Planning application No. 2020/93954. Lingards Road, Slaithwaite.

Herewith our formal objection to the above planning application. This letter is substantially the same as that submitted to the applicant in June 2020, in response to their public consultation.

Project	Housing at Lingards Road, Slaithwaite
Client	S B Homes Ltd
Drawing	SITE SECTIONS A, B, C
Scale	1:200
Date	13/10/2021
Dwg No	2019 572 53
Rev	A

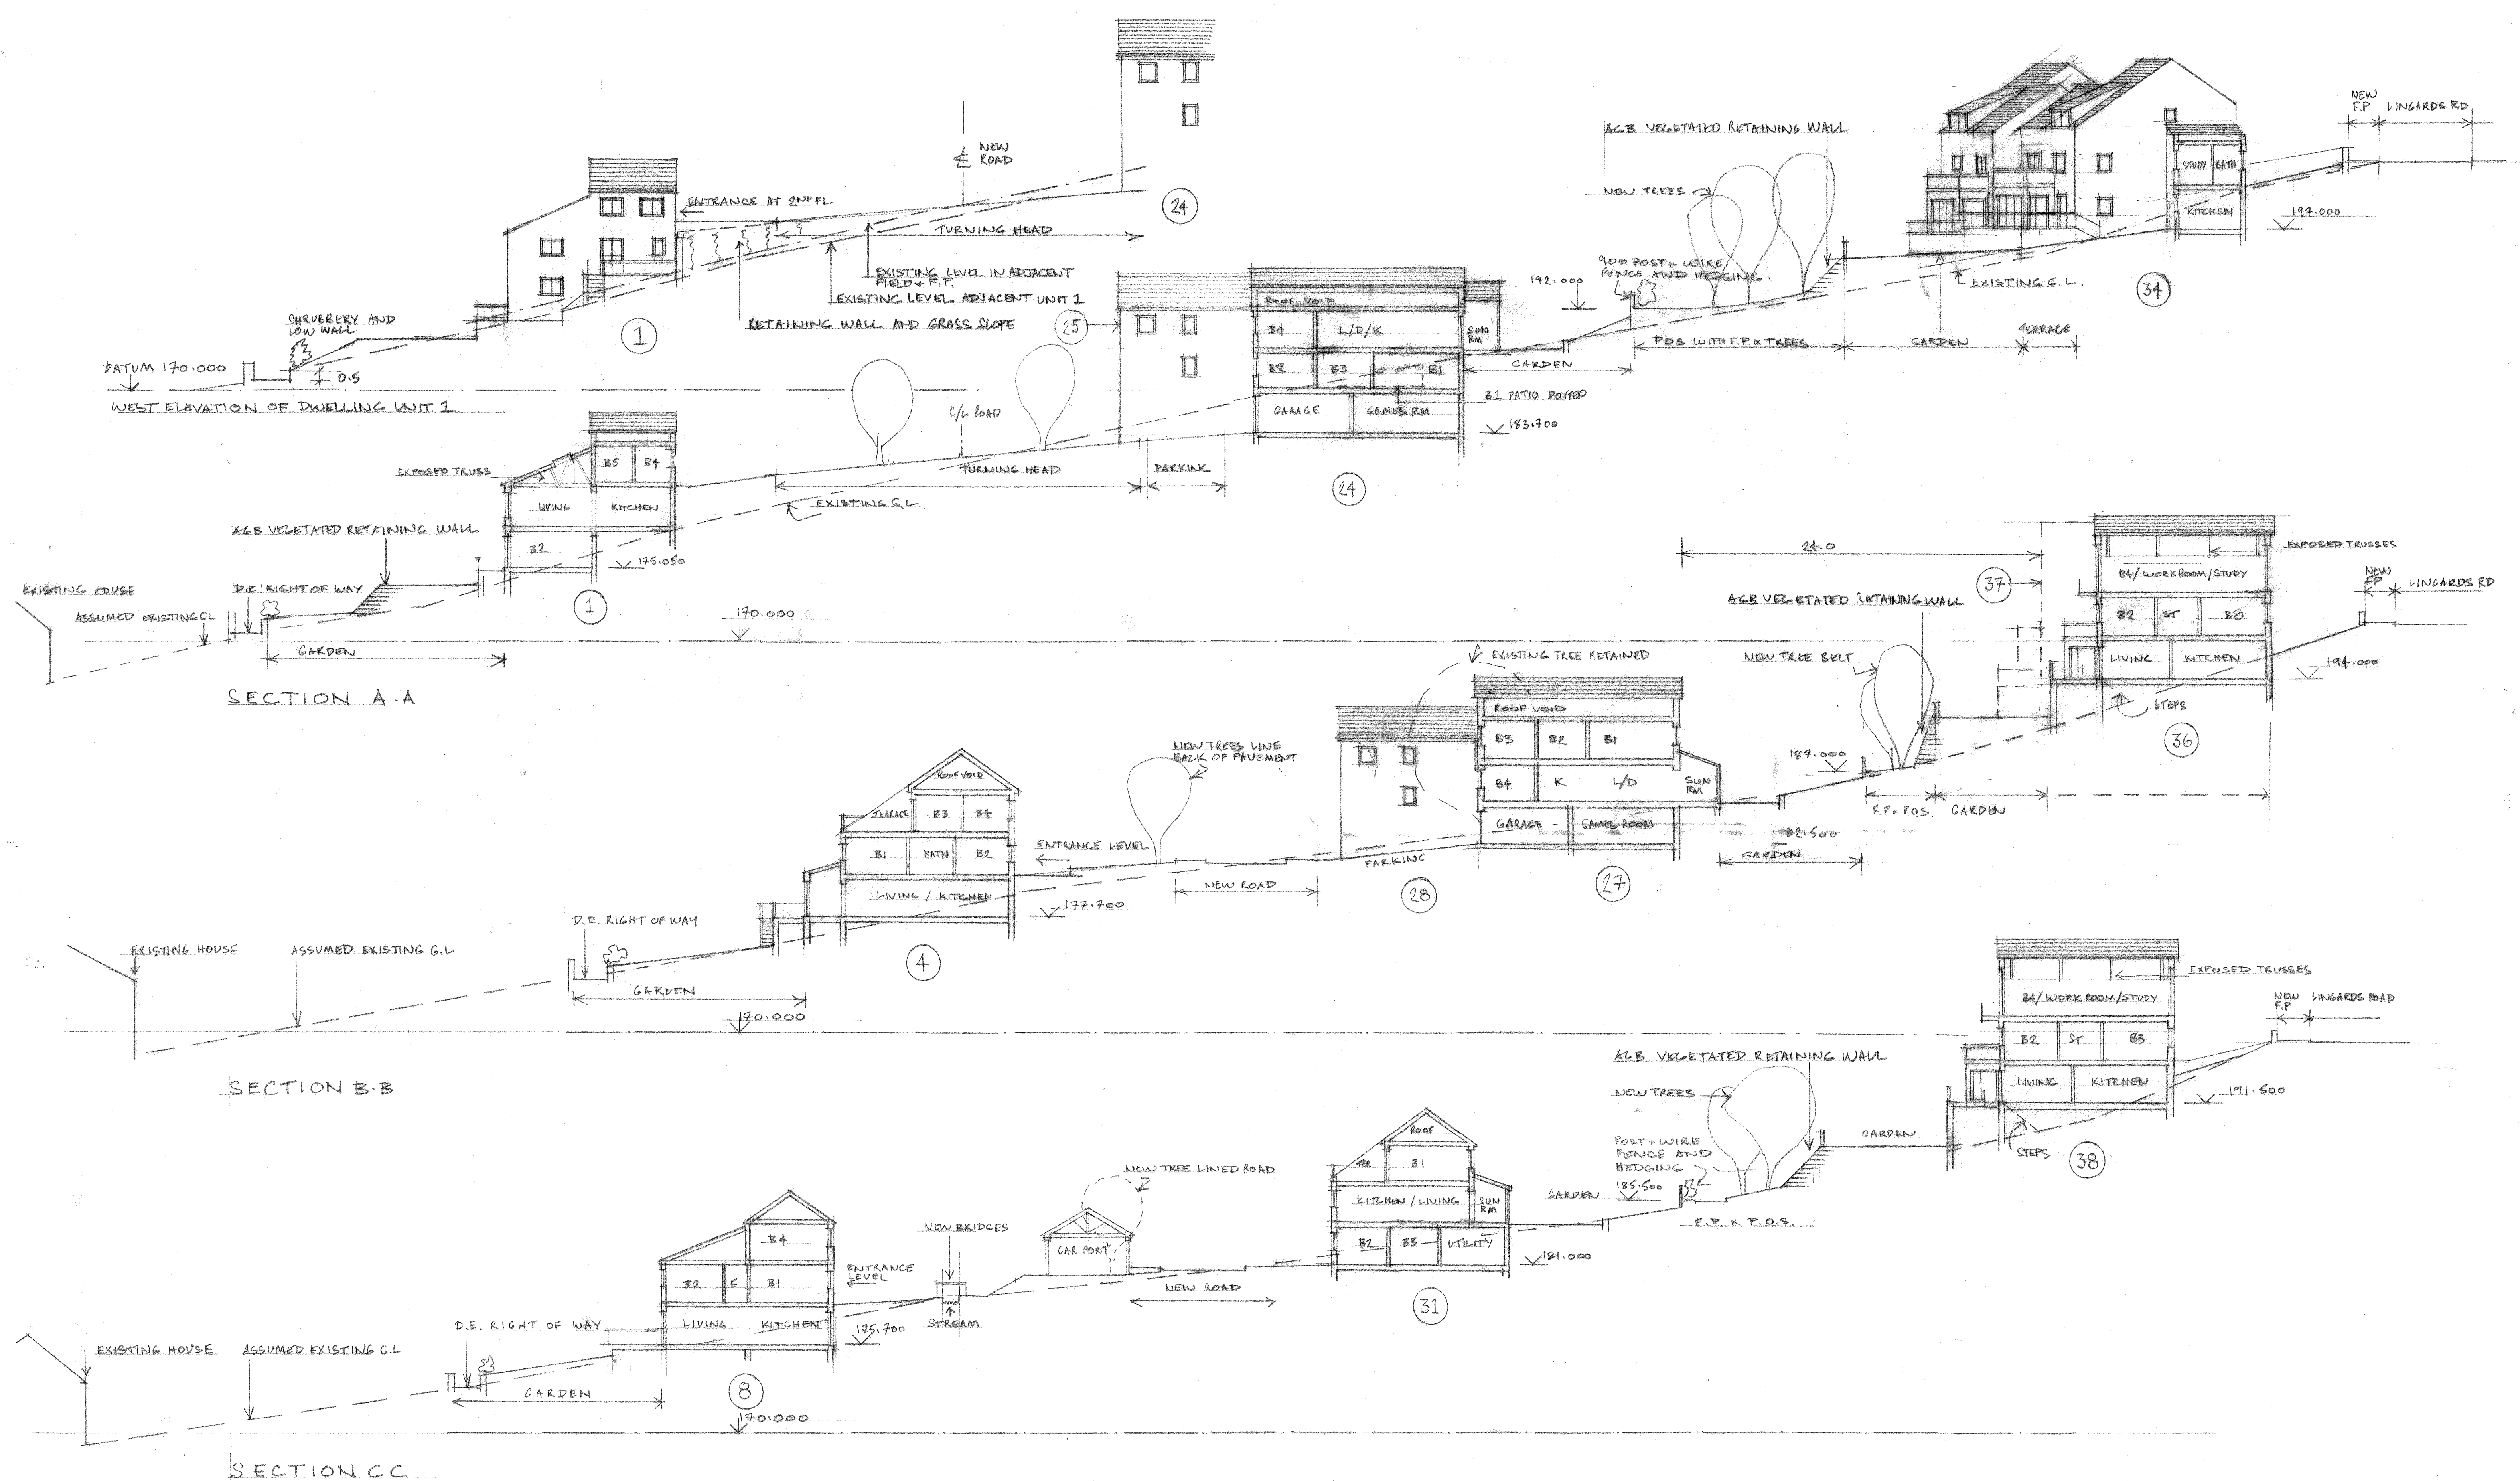
The marvellous view over Slaithwaite would be replaced by a solid terrace of four, gabled houses, significantly higher than our own house, separated by the minimum 21m (see site section c-c). One of these houses has been added since the consultation, and all four now dominate the listed farmhouse below. At the very least, these four units should revert to three, and be reduced in height by a full storey. Their entire omission would not render the development unviable and would recognise and respect the established situation of nos. 41-45 Lingards Road.
